Historic England

Arrangements for Handling Heritage Applications Direction 2021

**THE GROVE UNITED REFORM CHURCH, OXFORD ROAD, GOMERSAL,
CLECKHEATON, WEST YORKSHIRE BD19 4JY
Application No. 2023/90073**

Thank you for your letter of 7 February 2023 regarding the above application for listed building consent. On the basis of the information available to date, we offer the following advice to assist your authority in determining the application.

Only figured dimensions should be used.
 Scaled dimensions should be checked with the Architect.
 This drawing together with the design, is the property and copyright
 of the Architect and must not be reproduced without written
 permission

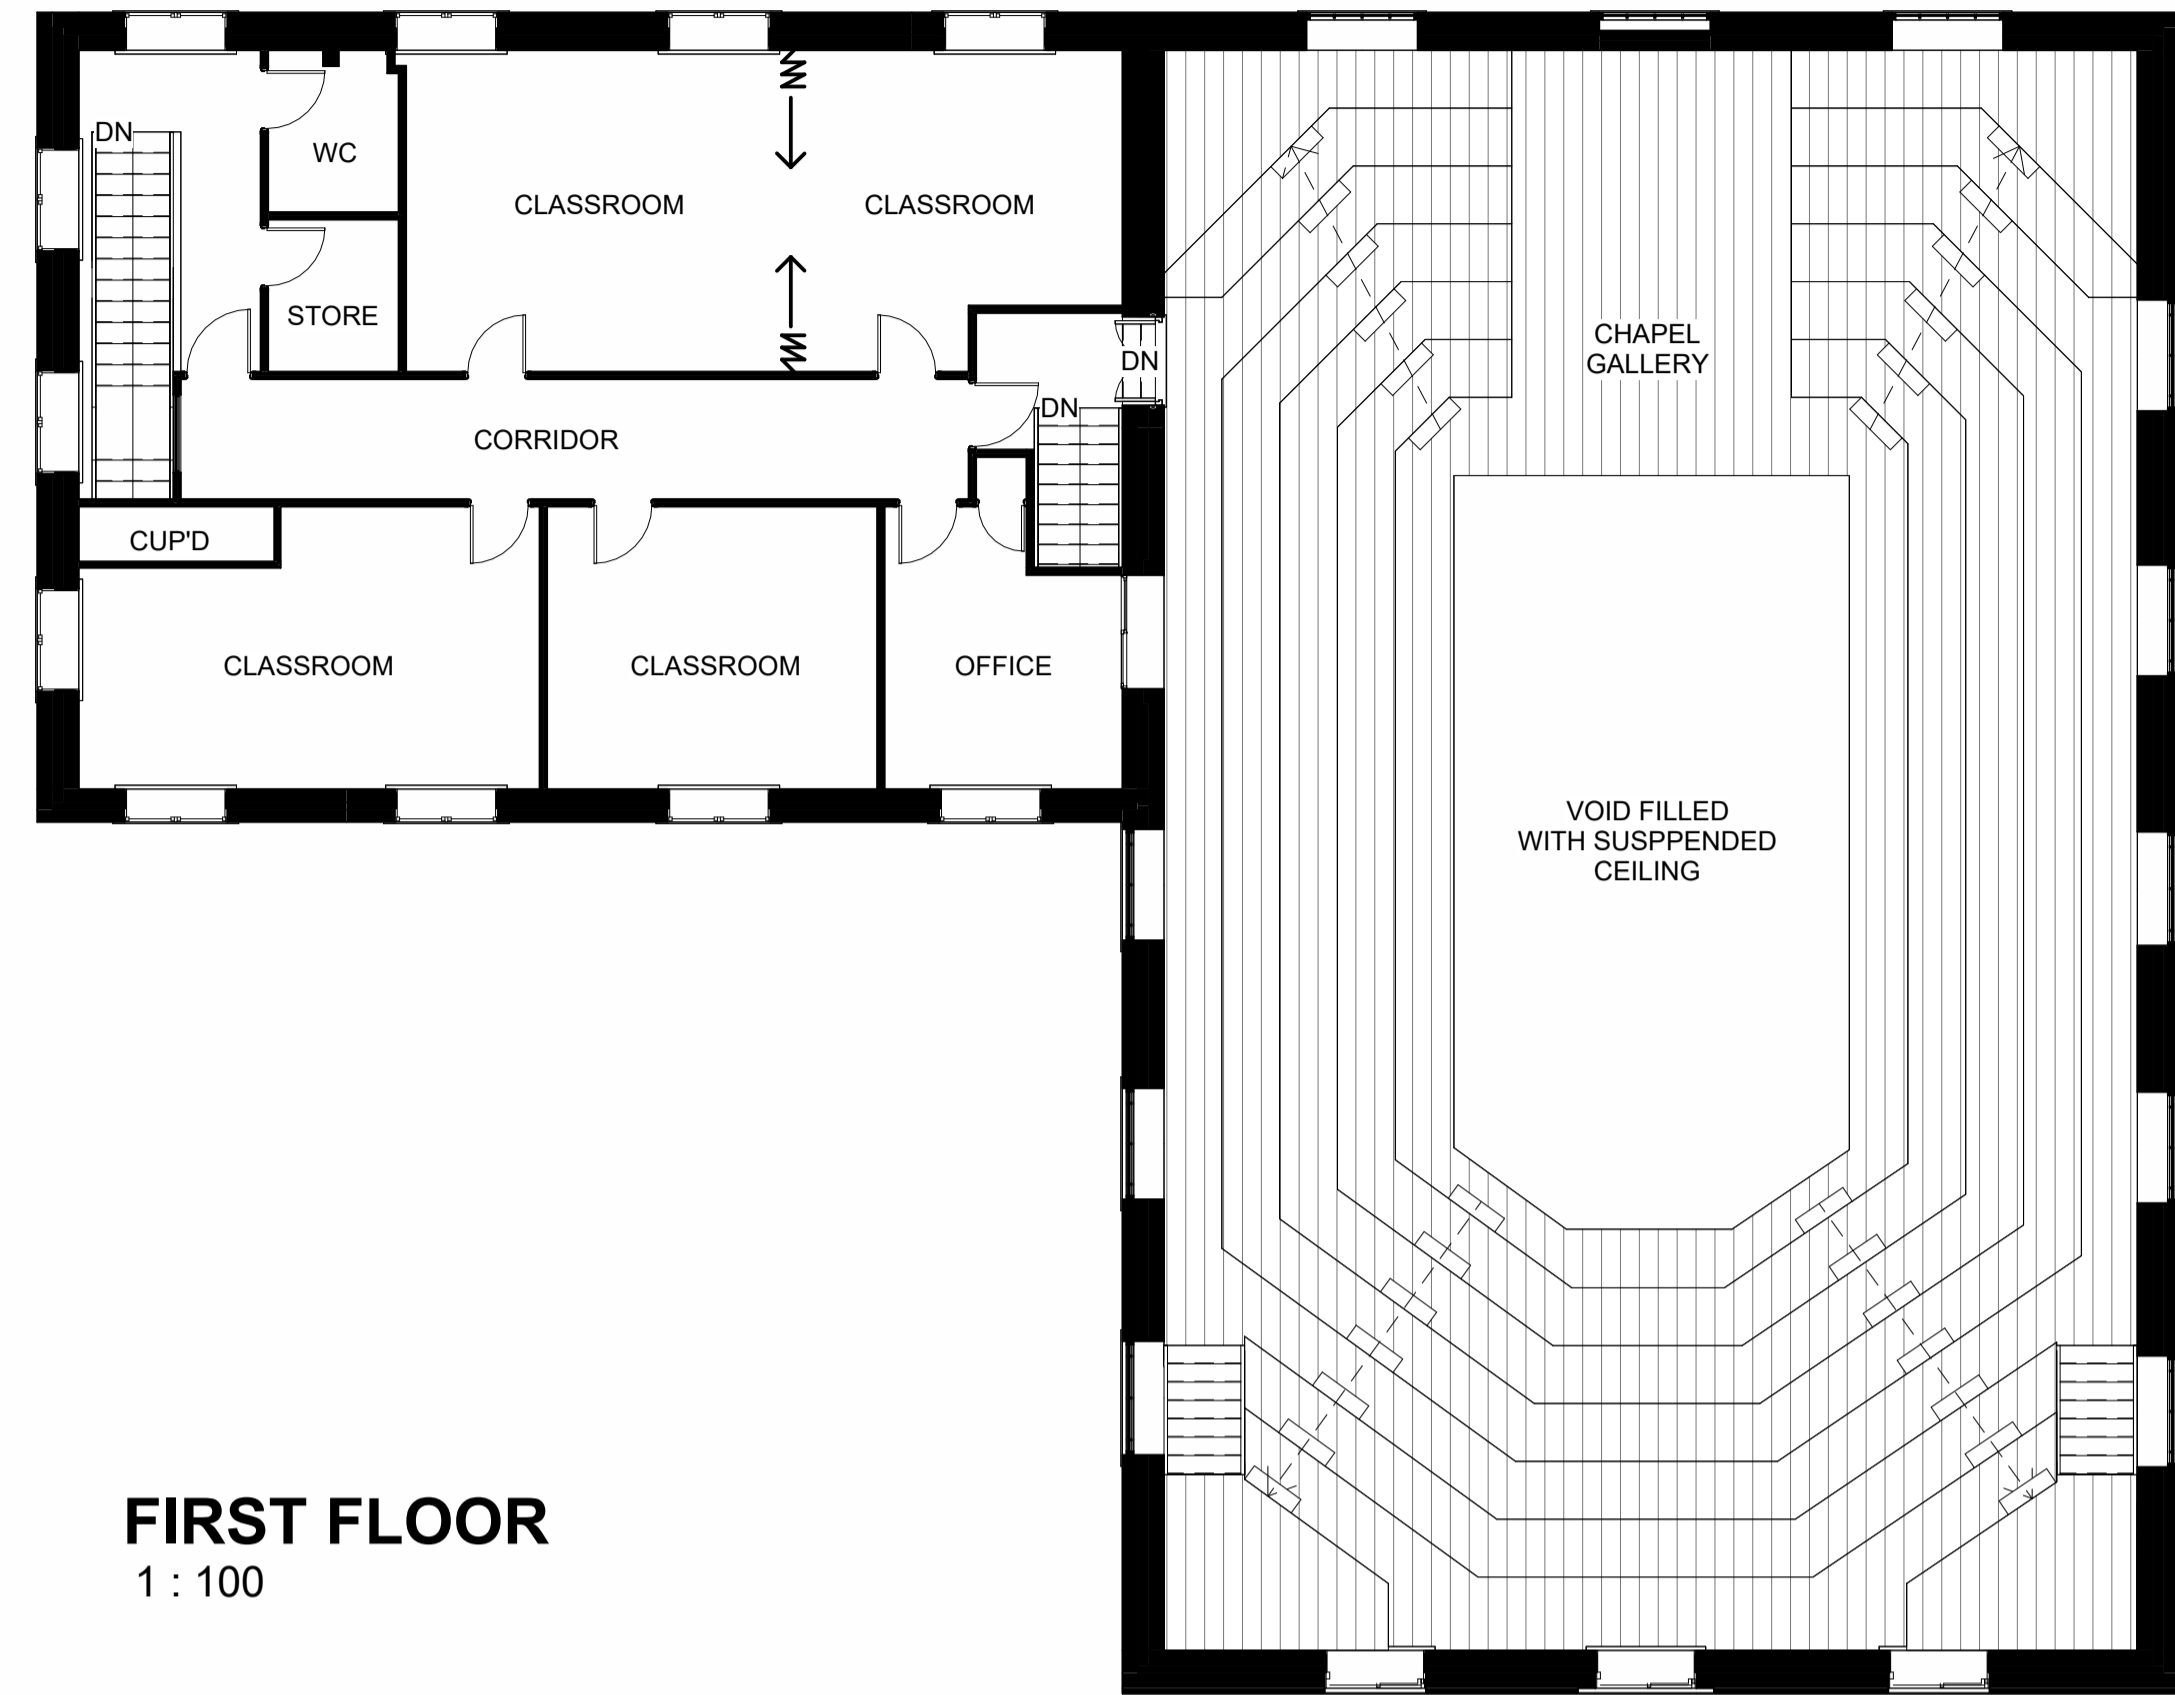
The proposed conversion of the main chapel space will result in the loss of the existing pews, pulpit and rail. The proposed subdivision of the space into apartments will also impact on the legibility of the original gallery and double-height space. This will cause harm to the significance of the grade II listed building as an example of an early nineteenth-century non-conformist chapel. There are some elements of the design that seek to mitigate this harm, for example the retention of the original pair of staircases, the retention of columns and the creation of a double-height space within two of the units. The harm could be reduced further if a reduced number of units was proposed for the chapel building. We defer to your local knowledge to assess whether there is a "clear and convincing justification" for the intensity of the proposed redevelopment, or whether it would be viable to provide fewer, larger units which would retain more of the original spatial qualities of the building. Whatever scheme is taken forward, we recommend opportunities are also taken to retain or reuse existing joinery within the building.
